Consultation Response from KC Public Health**2023/93539 Land adj, Ledgard Bridge Mill, Back Station Road, Mirfield, WF14 8NZ****Outline application, including the considerations of access appearance, layout, and scale, for the erection of a six-storey building to host 76 residential apartments (C3 use) and ancillary works comprising demolition of vacant building, formation of new access, parking areas, open space and landscaping; erection of cycle and bin refuse storage structures****Date Responded:** 4th January 2024**Responding Officer:** Louise Muhammad**Responding Ref:** 2023/93539**This response is from the Public Health Improvement Team.**

The submitted rapid health impact assessment has been reviewed. The Public Health Improvement Team have identified further measures and considerations surrounding the development issues, as outlined in the table below, which look to enhance the proposed development and further improve health and wellbeing outcomes for people and place. We kindly request that the measures set out in the table for each development issue are

Project: Proposed residential scheme at Ledgard Bridge, Mirfield
 Client: Birks Executive Homes Ltd, Cawthorne, Bamsley S75 4EJ
 Dwg Title: 170012_Site Plan
 Scale: 1:200 @ A0
 Date: Jan 22

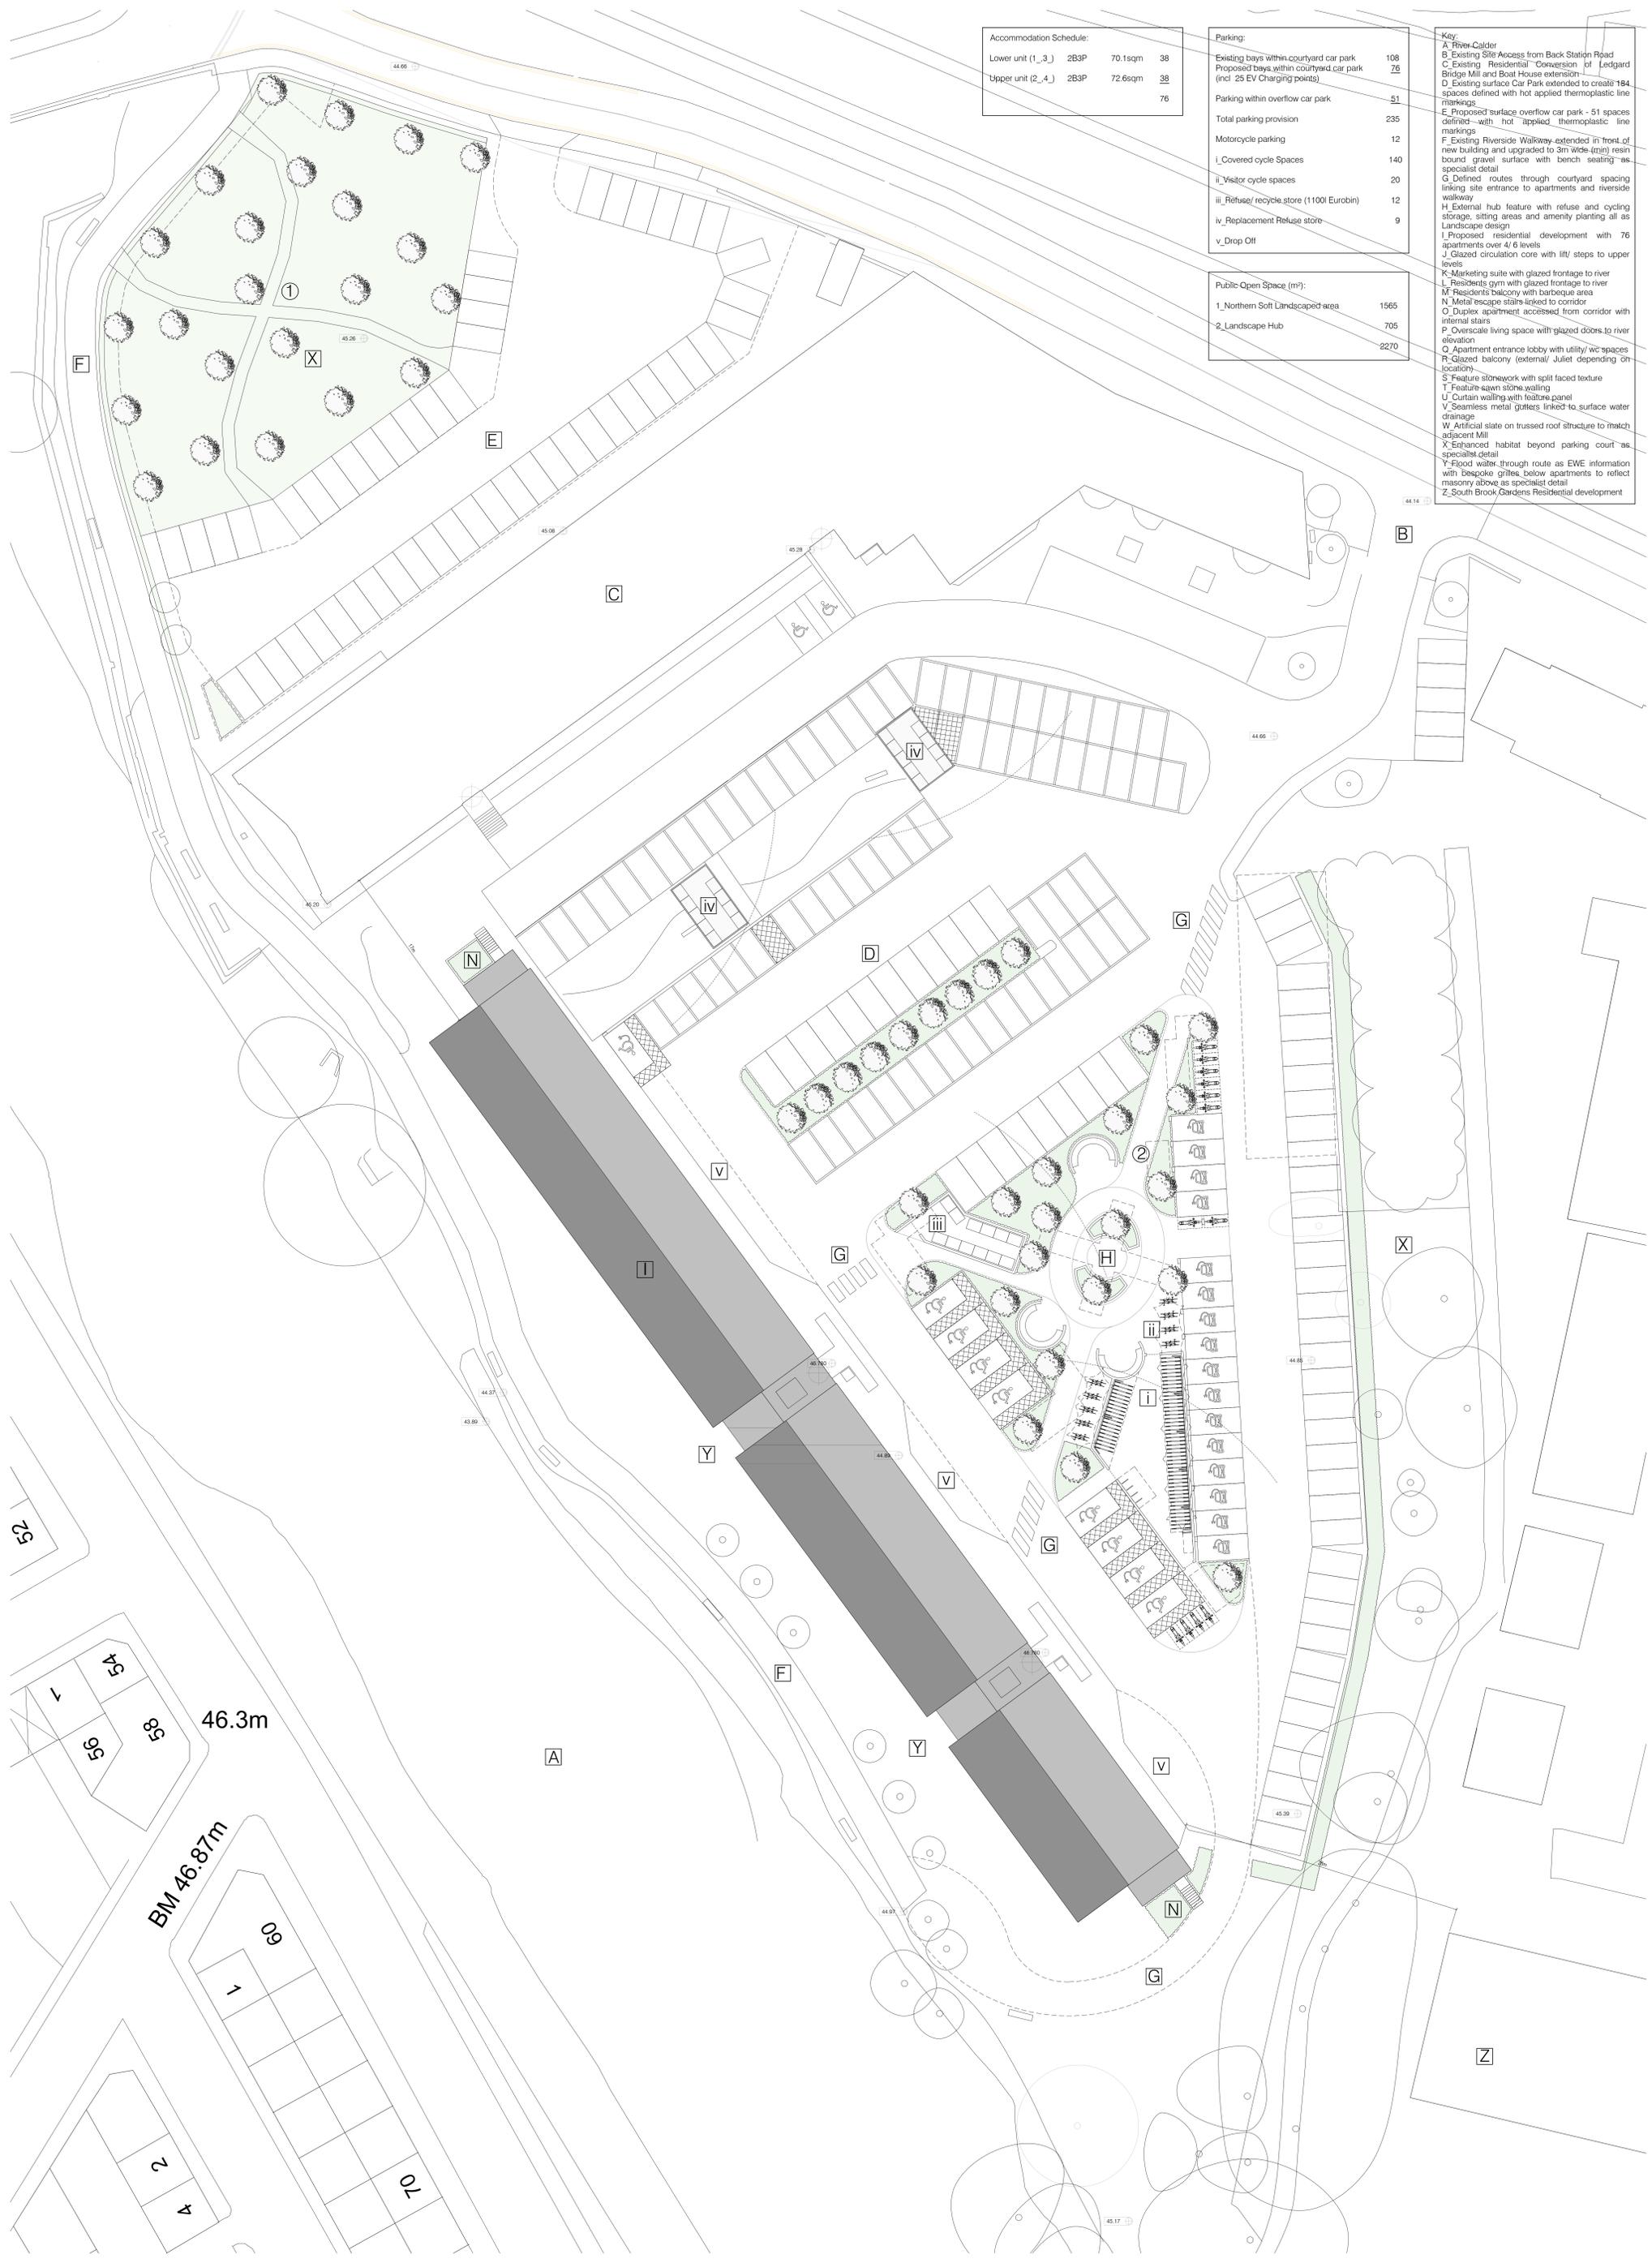
<p>With regards to those residents who want to or have to use cars there seems to be adequate parking provision-however it was unclear from what has been submitted whether or not any consideration has been given to visitor parking (apologies if it is stated and been overlooked). However, good to see the provision of 18 visitor cycle spaces.</p>
<p>Access to Open and Green Spaces</p>	<p>It is noted that there will be no 'play space' contained within the development even though its stated the apartments are appropriate for one child/small families as part of the tenancy mix. If it is at all possible to include some provision it would really improve quality of life for those with small children and give added capacity to just a small balcony. We appreciate due to being located near to a river/water way there may be other factors to consider with regards to safety-but we encourage further exploration.</p> <p>However public health welcome the inclusion of a 'pocket-park' and the indicative landscaped areas that have been earmarked across the development. We would also strongly suggest these areas are made smoke-free.</p> <p>It is anticipated there will be very little impact on biodiversity and wildlife-but where some risk has been identified, appropriate mitigations have been considered.</p>

<p>Community Cohesion and Social Support</p>	<p>It is noted that the currently vacant martial arts building on site is scheduled to be demolished to provide overspill carparking that serves both the existing and proposed residential development. PH would recommend revisiting this decision and exploring whether or not this building could be designed as a more communal space/facility with some renovation.</p> <p>The inclusion of a seating area, pocket park, communal gym, etc are all welcomed and will facilitate social cohesion and connection for residents.</p> <p>The intention to explore the setting up of a car club on site in future years will also support cohesion and sharing as well as support greener more sustainable travel.</p>
<p>Climate Change</p>	<p>The plans to incorporate energy saving lights on timers and water saving devices within sanitary ware etc.</p> <p>We encourage the exploration with renewable energy providers as stated with regards to solar panels on the roof (subject to funding) as well as any other feasible measures (e.g heat pumps etc)</p>
